CITY OF PORTLAND, MAINE

HISTORIC PRESERVATION BOARD

March 27, 2013

Re: Front porch replacement, 12-14 Taylor Street

1 FRONT ELEVATION
SCALE: 1/4" = 1'-0"

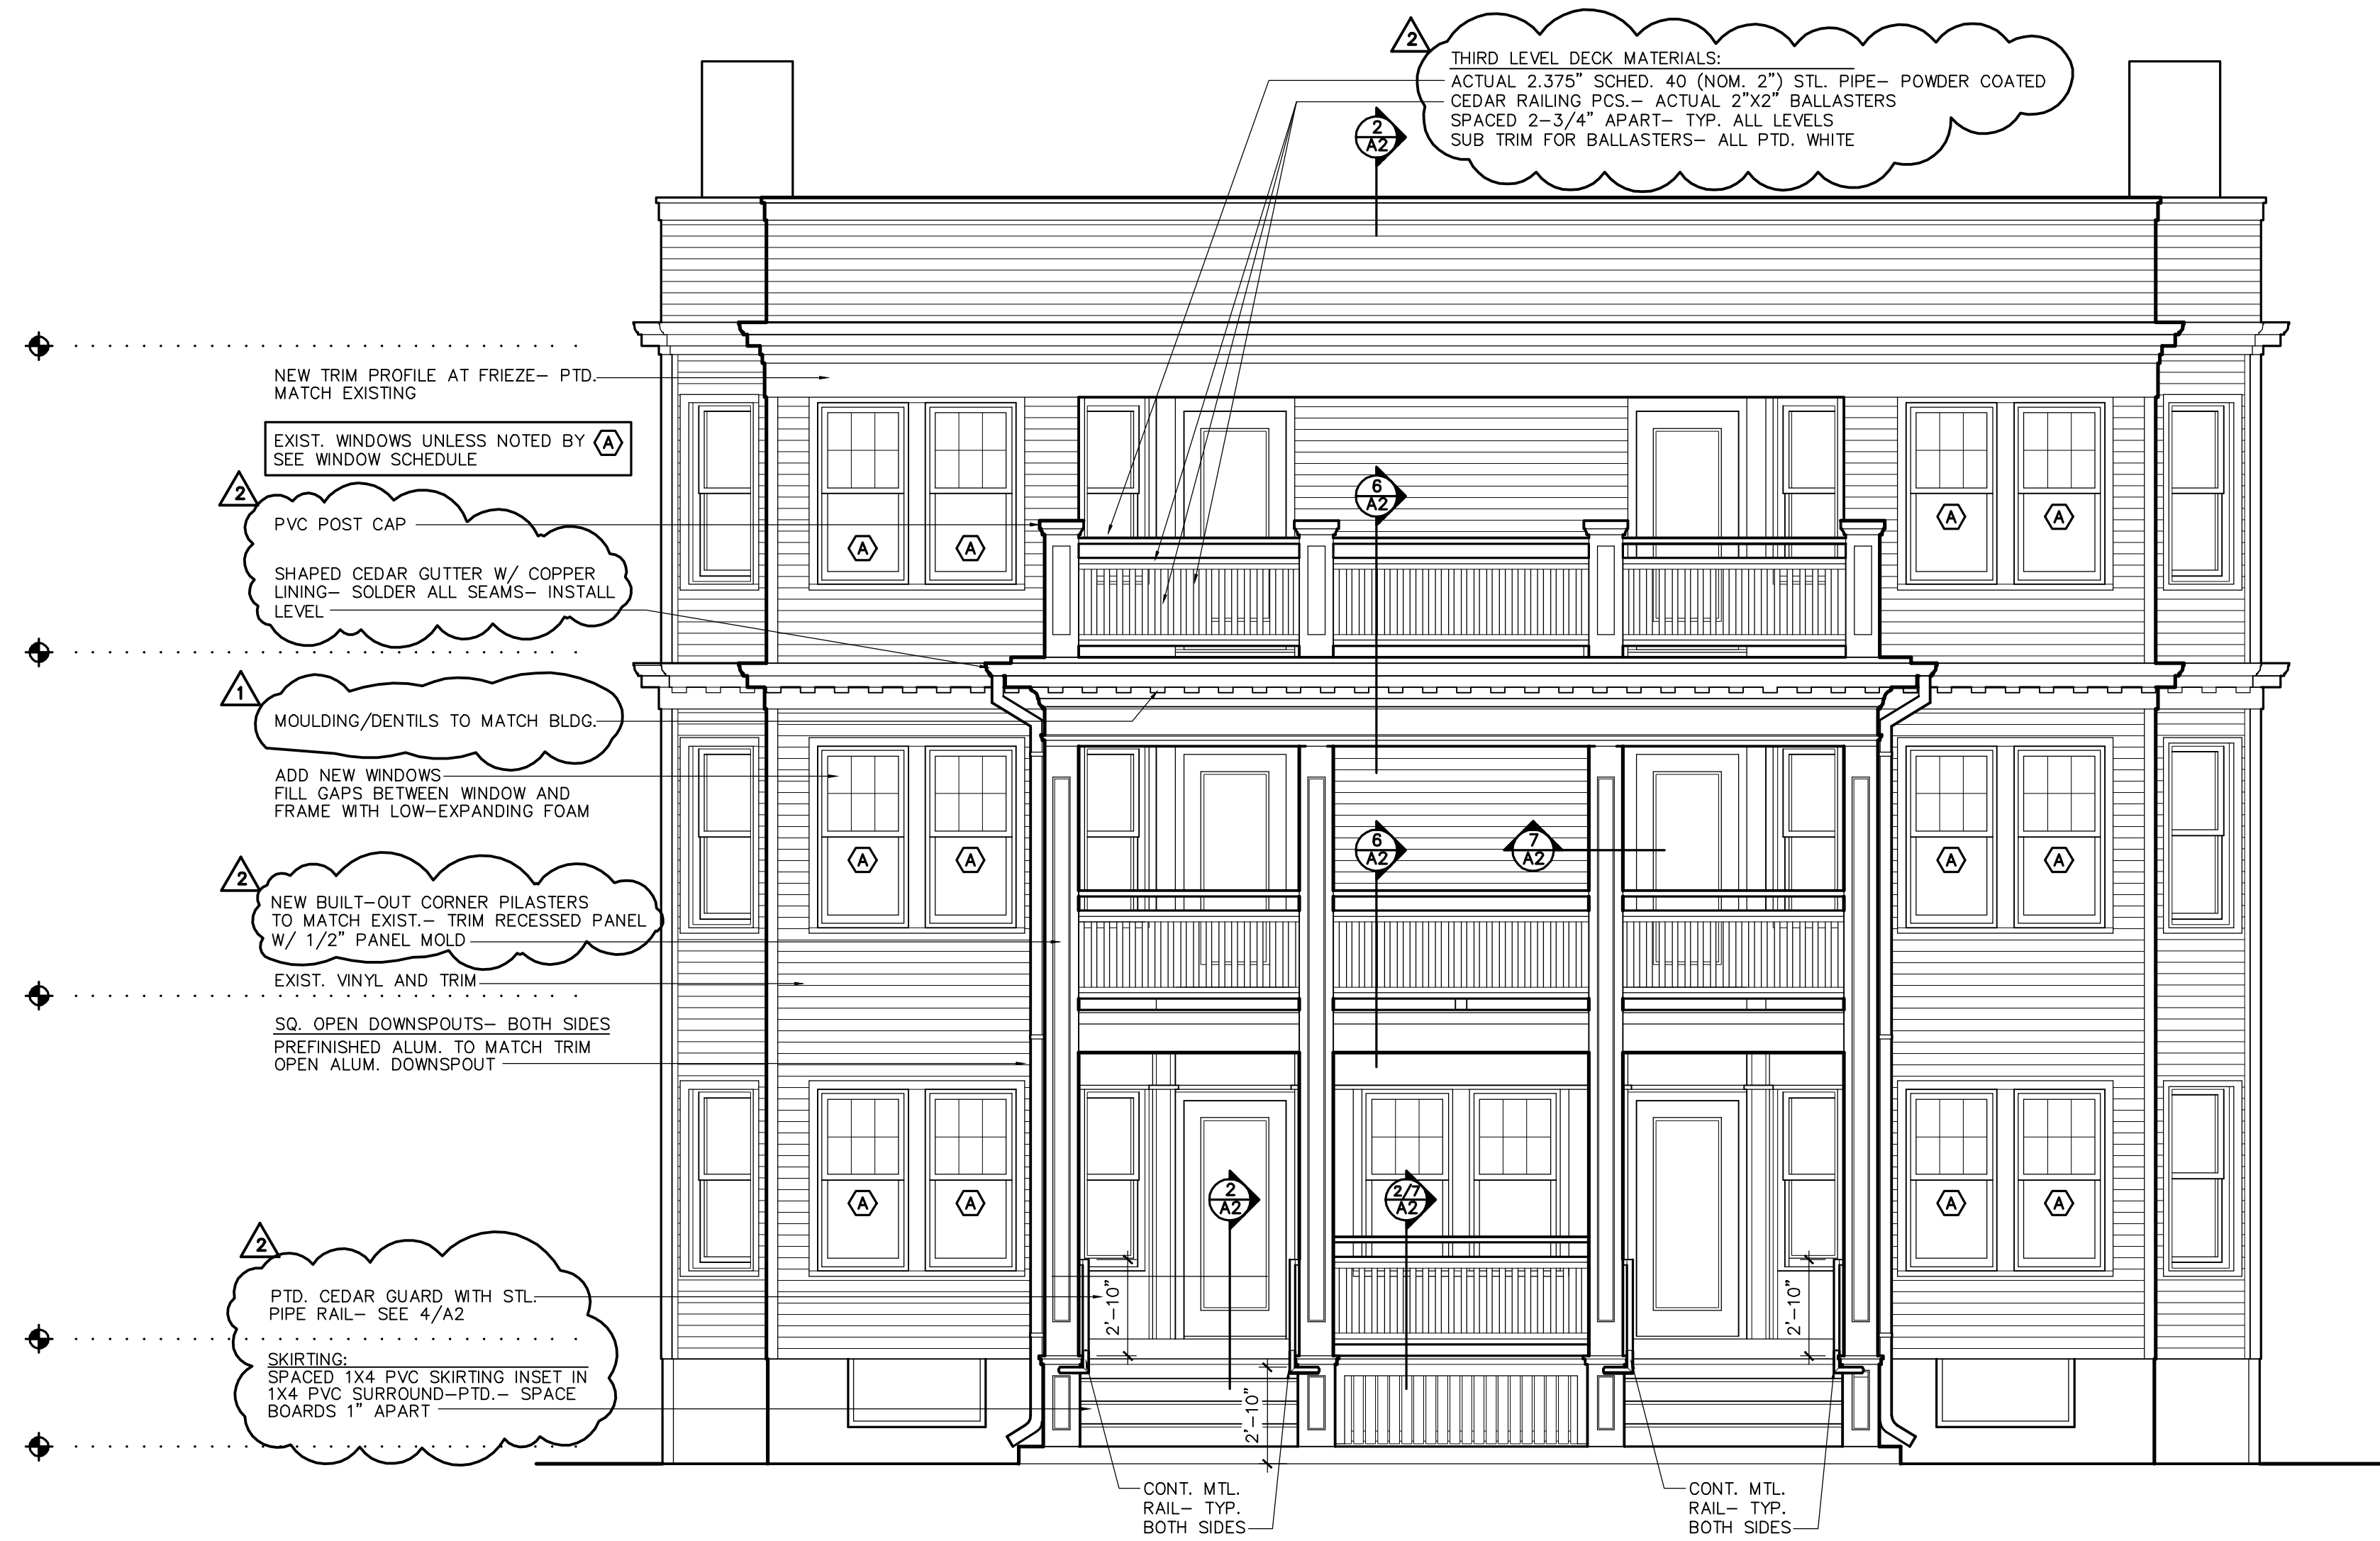
- The main railing system to be lowered to 36".
- A 2" diameter rail may be added to meet the 42" railing height requirement, if necessary. Applicant to inquire as to whether a 36" rail will be adequate.
- Consistent with the porch's 1924 appearance, the two center posts with caps shall be continued at the third floor level. The intermediate posts shown on the submitted elevation shall be eliminated.
- The top of the posts at the second floor level shall feature a simple capital, as shown in the 1924 photo.
- The inside of all recessed panels shall feature a transitional molding.
- The replacement gutter shall be a metal lined or metal gutter rather than a wood gutter.
- Copper caps on post tops to be eliminated.
- Original skirting detail to be replicated.
- The attachment of the handrail on the first floor posts to be moved to the side of the posts, not the front face.

Note: The Board strongly encourages the replacement of the existing picture windows to paired double hung windows, as shown in the submitted elevations. The Board also encourages a return to 2 entrances, consistent with the building's original appearance. If the applicant elects to undertake these additional changes, no further review will be required.

Revised drawings reflecting the modifications outlined above shall be submitted to staff for final review and approval.
